Horsham
District
Council

Gatwick Northern Runway Project DCO (Project Reference: TR020005)

Deadline 7 Submission -15 July 2024

**Crawley Borough Council (IP Ref: GATW-AFP107),
West Sussex County Council (IP Ref: 20044715),
Horsham District Council (IP Ref: 20044739) and
Mid Sussex District Council (IP Ref: 20044737)**

Title
Gatwick Business as Usual (BaU) Signalisation Scheme Concept Design APFP Regulations 5(2)(q) - Sheet 1 Highway Layout Plans - North Terminal

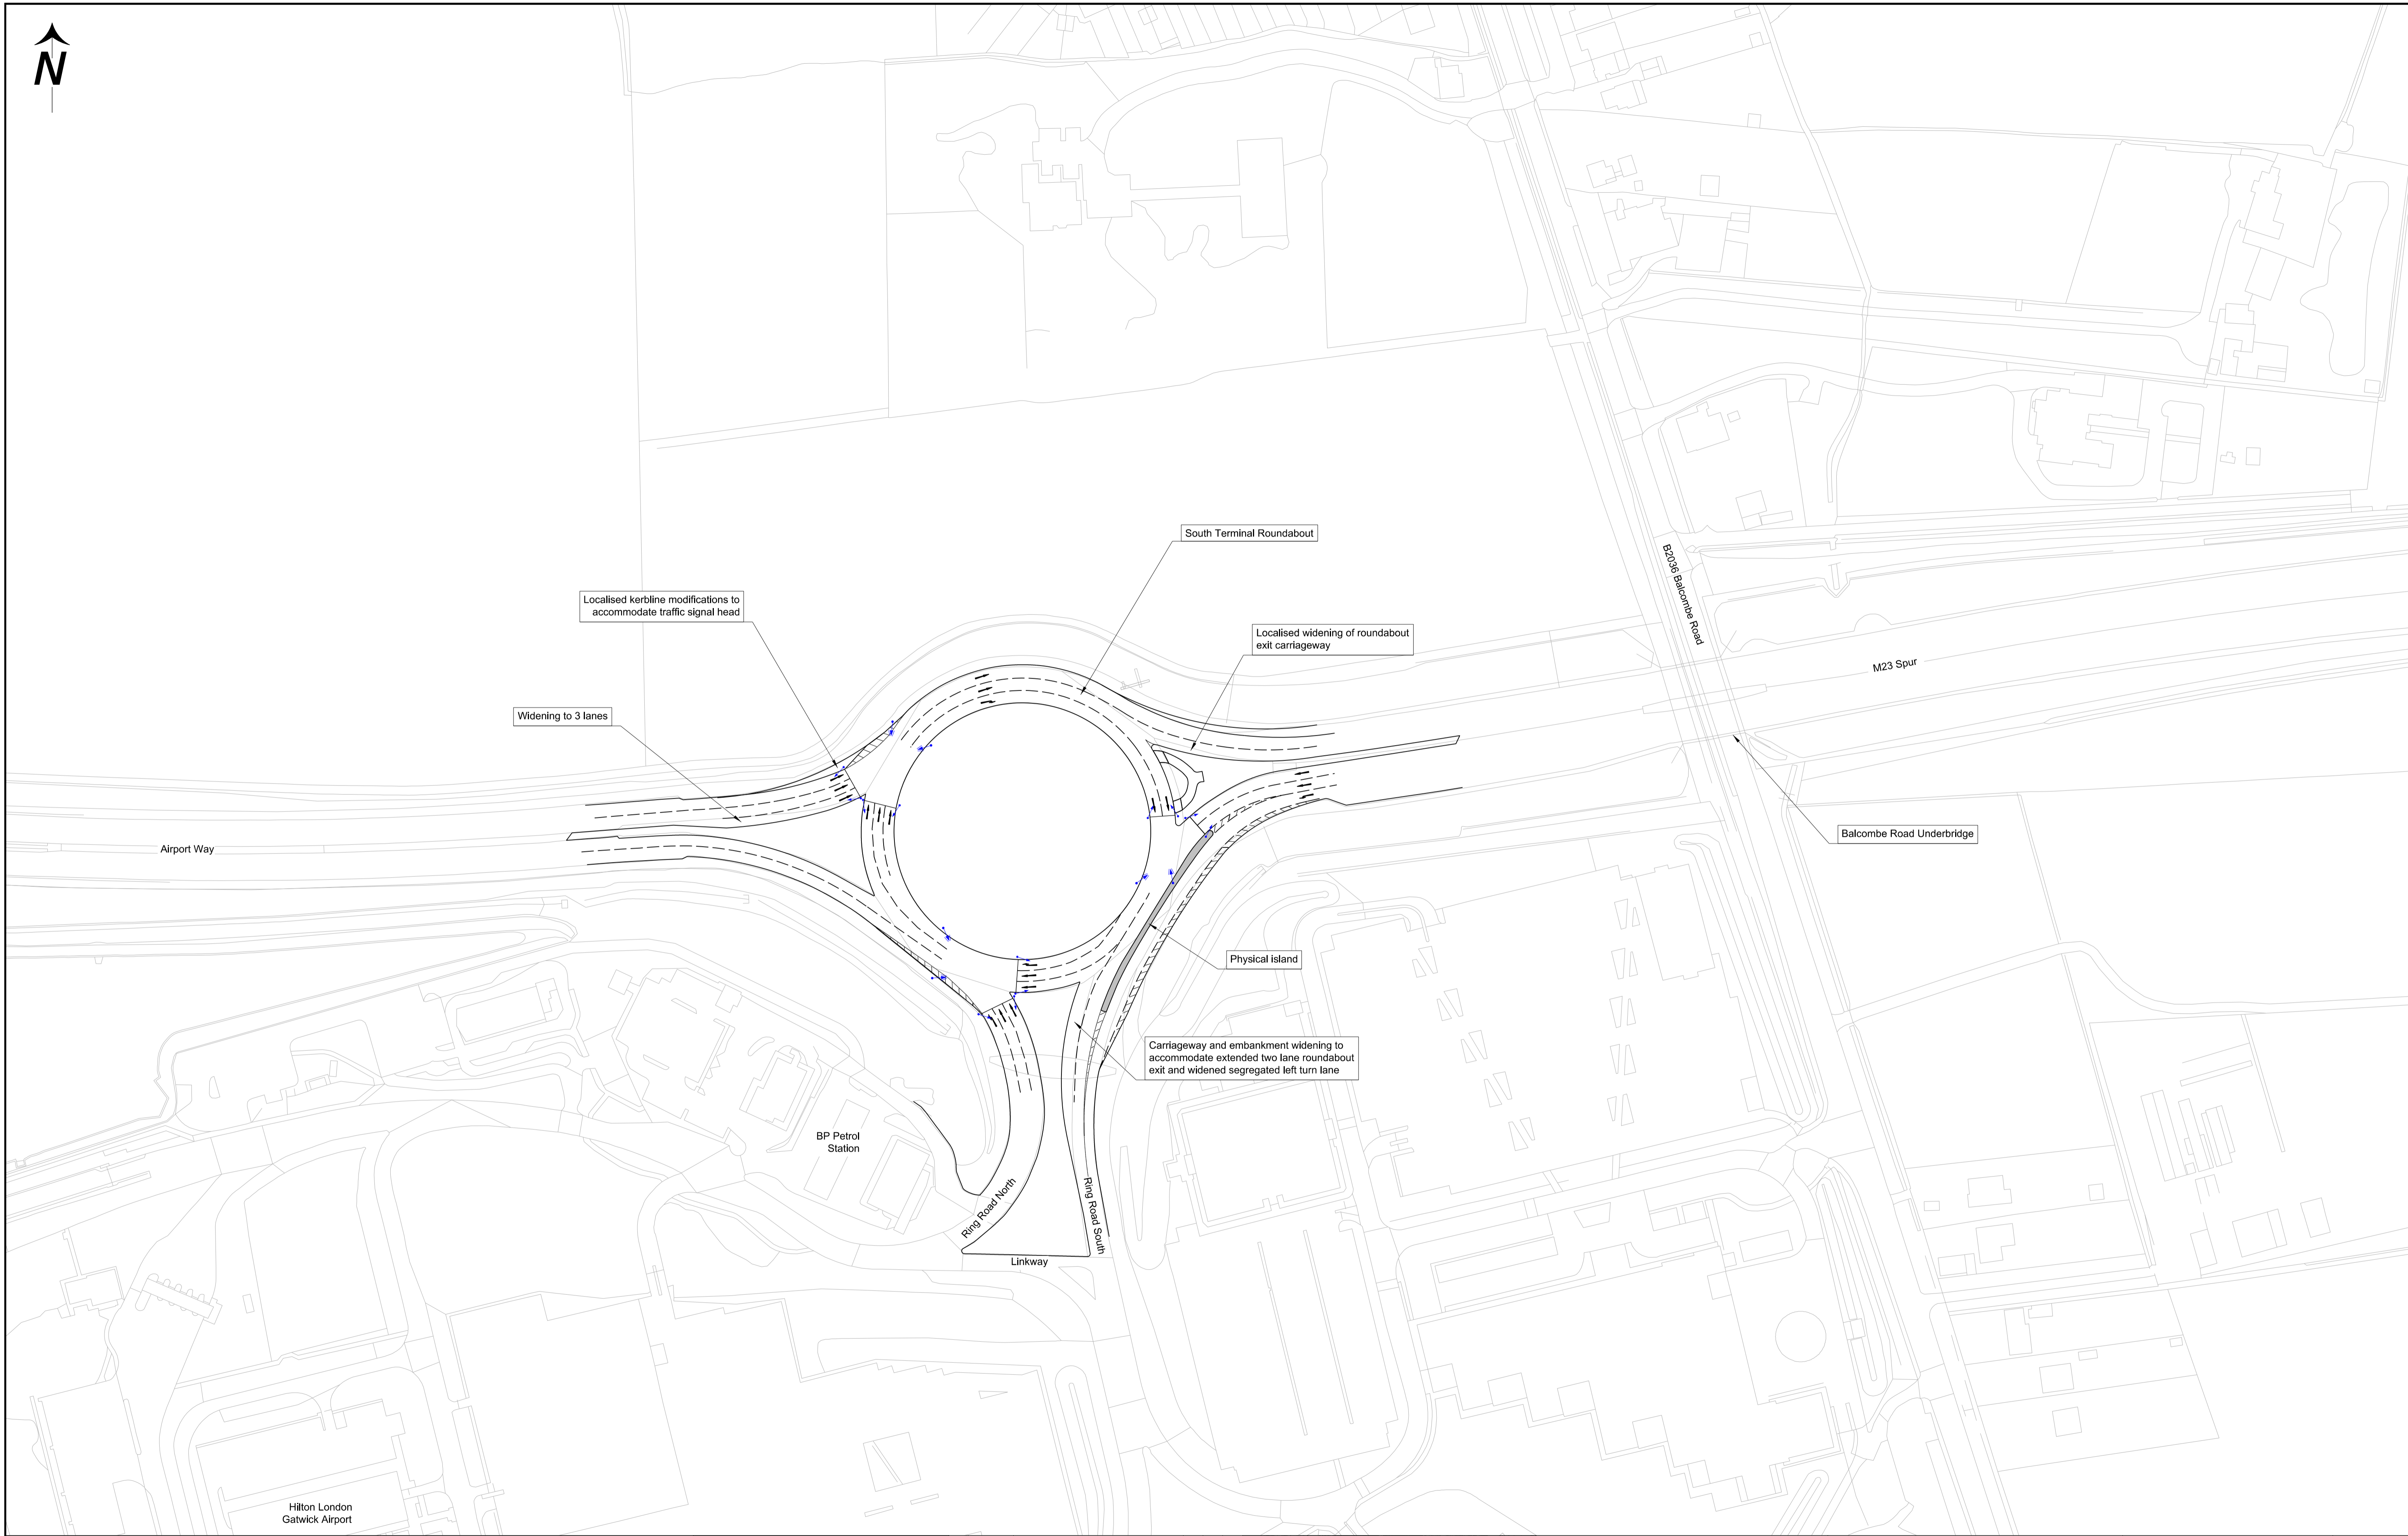
- 3.1 The Highway Authority notes the submission of the North and South Terminal Roundabouts BAU Improvement Scheme Plans [REP6-012] and the inclusion of an additional requirement in the draft Development Consent Order [REP6-007] to secure these works. The works are required to be delivered prior to the first of, the commencement of dual runway operations, commencement of the first of works numbers 35 (South Terminal junction improvements) and works number 36 (North Terminal junction improvements or the third anniversary of the commencement of the authorised development.

- 3.2 The ExA have issued ExQ2, to be responded at Deadline 7, and question TT.2.12 relates to the proposed BAU Improvement Scheme Plans at North and South Terminal Roundabouts. These works are not within WSCC's highway network and are within National Highway's network or within the Applicant's control. The ExA have asked whether there should be controlled pedestrian and cycle crossings on any elements of these design layouts.

- 3.3 Notwithstanding these works are on National Highway's network, WSCC as Highway Authority has the following views on pedestrian and cycle access. Given the nature of the road network at South Terminal Roundabout, and that there are no existing pedestrian or cycle desire lines, there is not considered to be a need for formal crossing points at this location. At North Terminal Roundabout given existing desire lines consideration could be given to pedestrian crossing improvements. These could be at North Terminal Approach, on the pedestrian desire line underneath the structure that carries the Gatwick Airport Shuttle Transit to connect into the footway that leads towards Northway. Secondly, consideration could be given for pedestrian crossing enhancements at Longbridge Way to provide a crossing over Longbridge Way that provides an onwards connection to footpath 346_2Sy. Given the location and likely use of these crossings they may not be signalised controlled crossings but footway enhancements with dropped kerbs, tactile paving and pedestrian refuges may be able to be provided.
